ABP-318540-23

**Proposed Open Cycle Gas Turbine (OCGT) at Tarbert Power Station,
Tarbert.**

**Submission to An Bord Pleanála by the Development Management Section
of Kerry County Council.**

EXISTING AND PROPOSED FOUL WATER DRAINAGE (SEWAGE)
 SHEET 8 OF 8

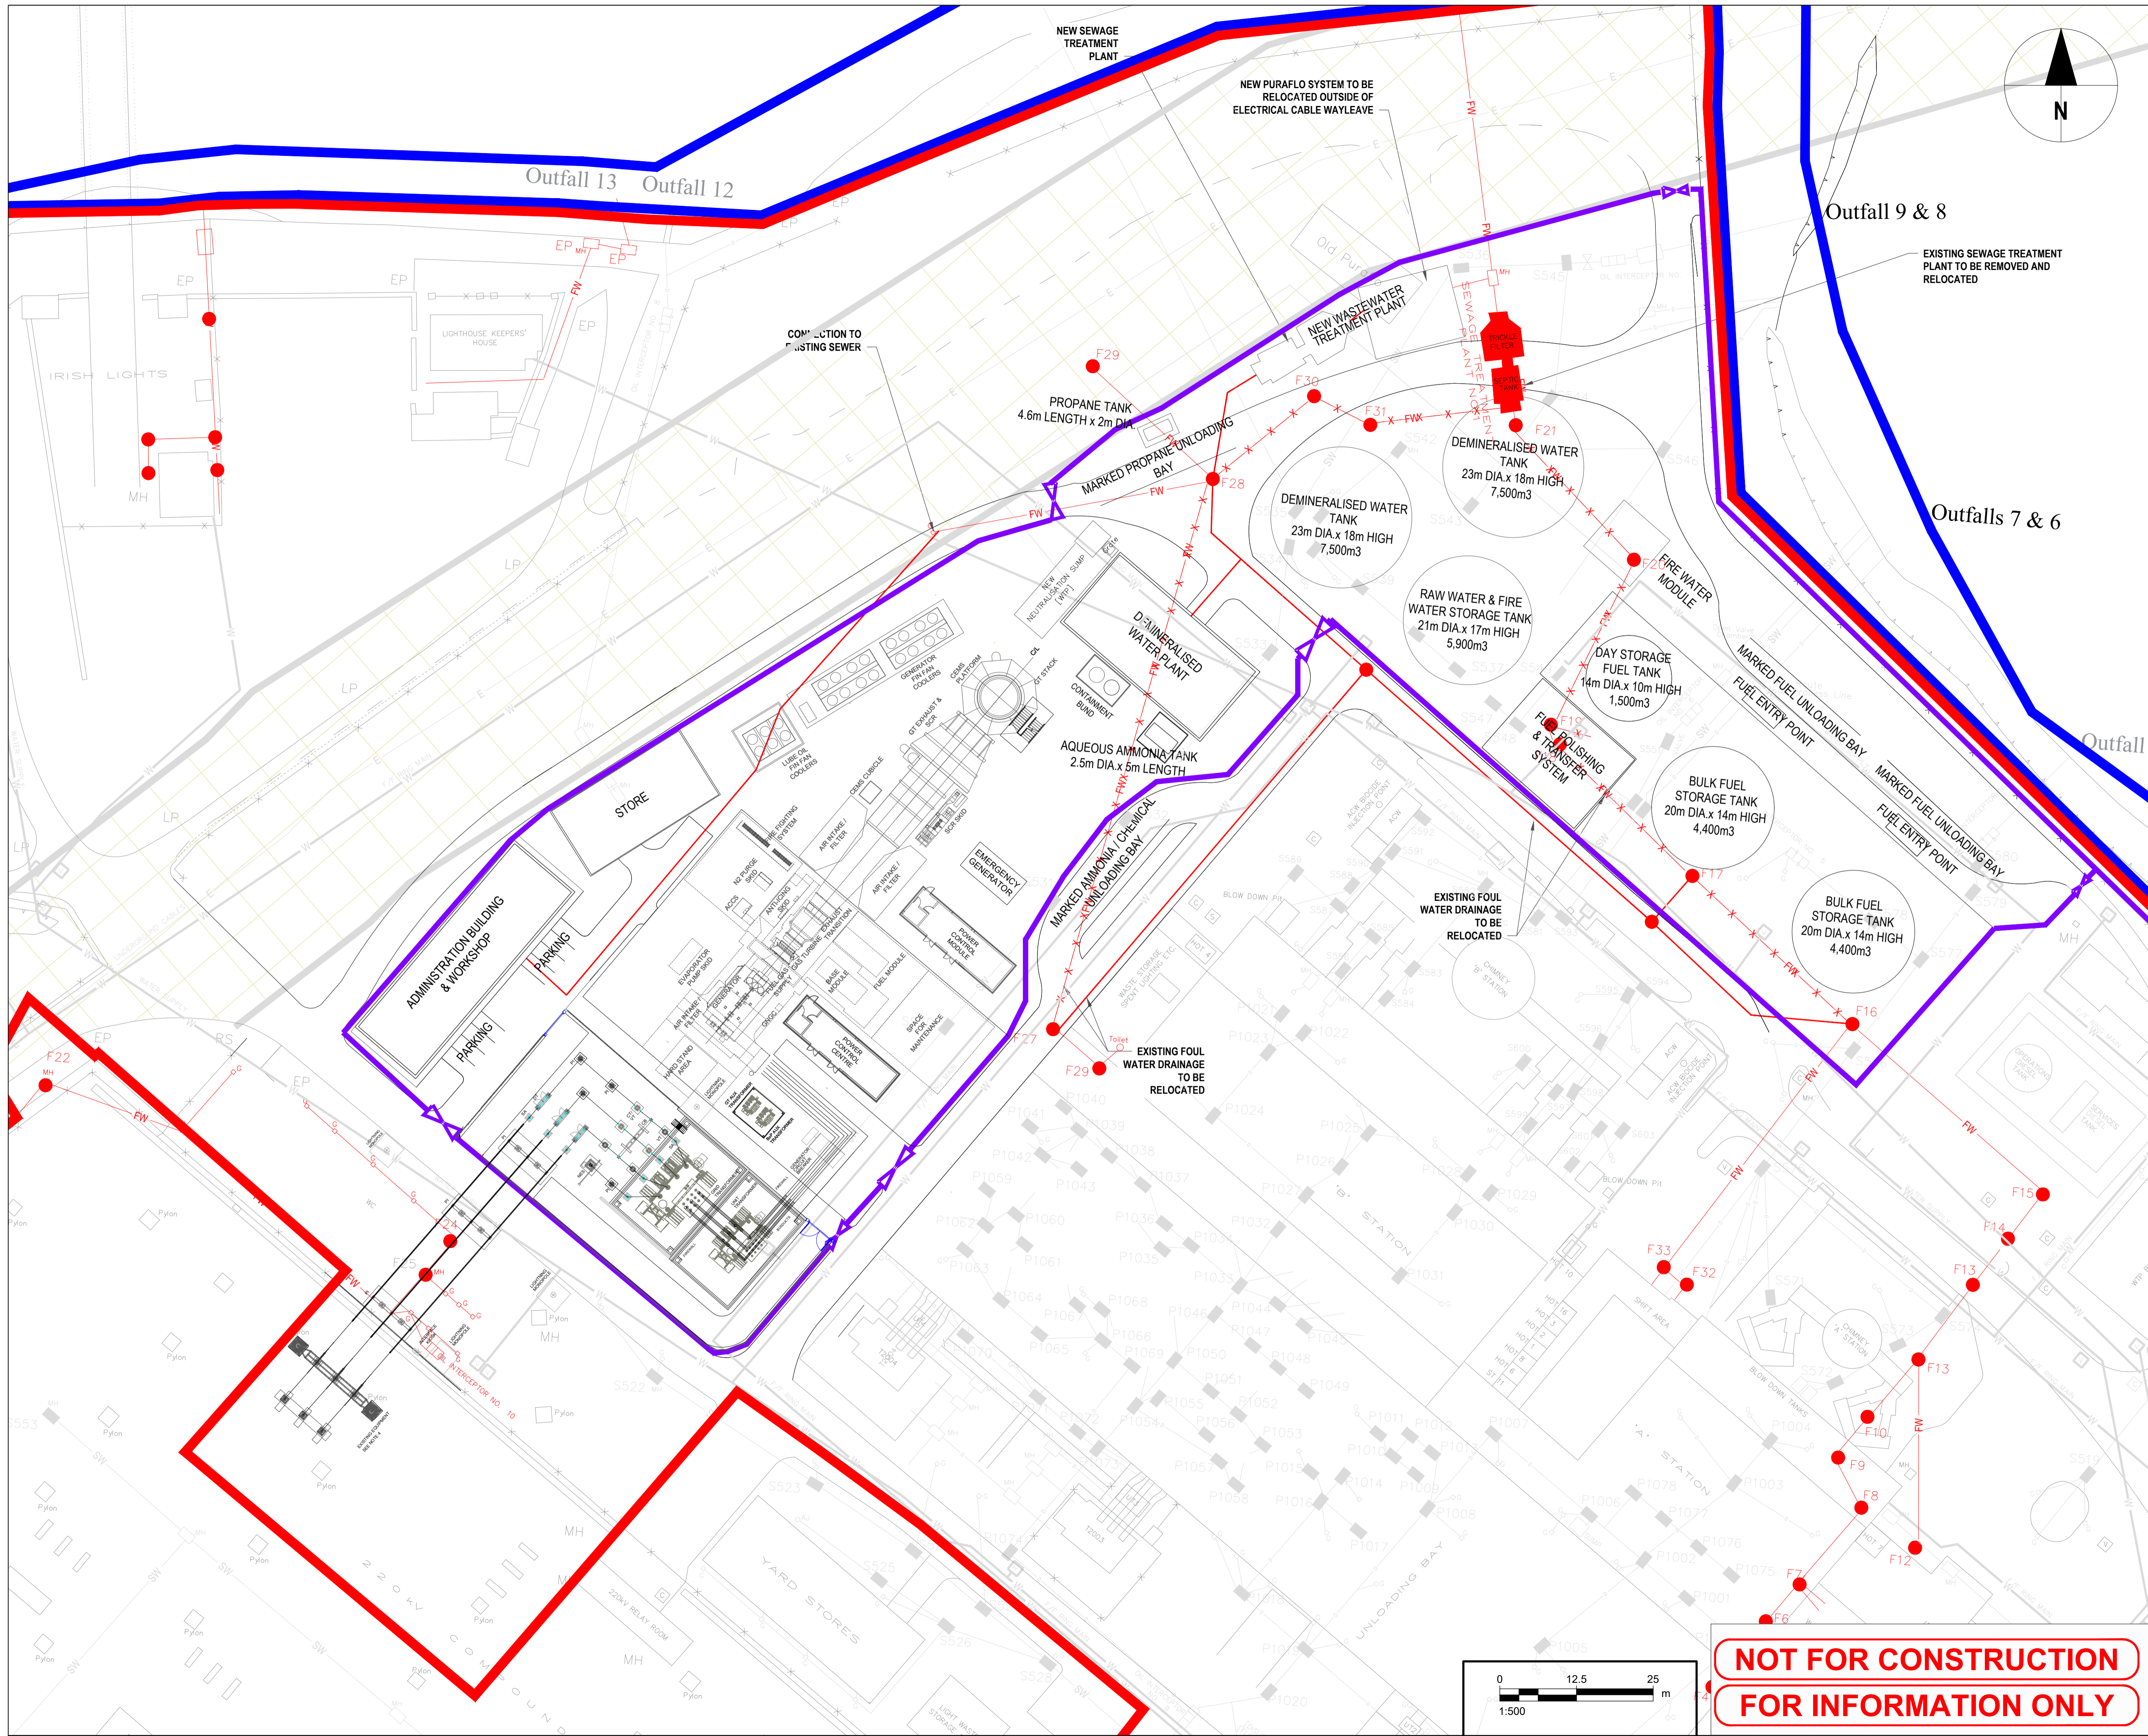
In relation to the management of domestic wastewater onsite, the Environment Section indicates that limited information has been submitted in relation to the volume of domestic wastewater likely to be generated nor has a site assessment been carried out in line with the Environmental Protection Agency (EPA), A Code of Practice for Domestic Waste Water Treatment Systems. The Environment Section suggests that An Bord Pleanála requests the applicant to engage a suitably qualified site assessor to carry out a comprehensive site assessment and furnish An Bord Pleanála with a proposal for on-site treatment of domestic wastewater in line with the EPA Code of Practice.
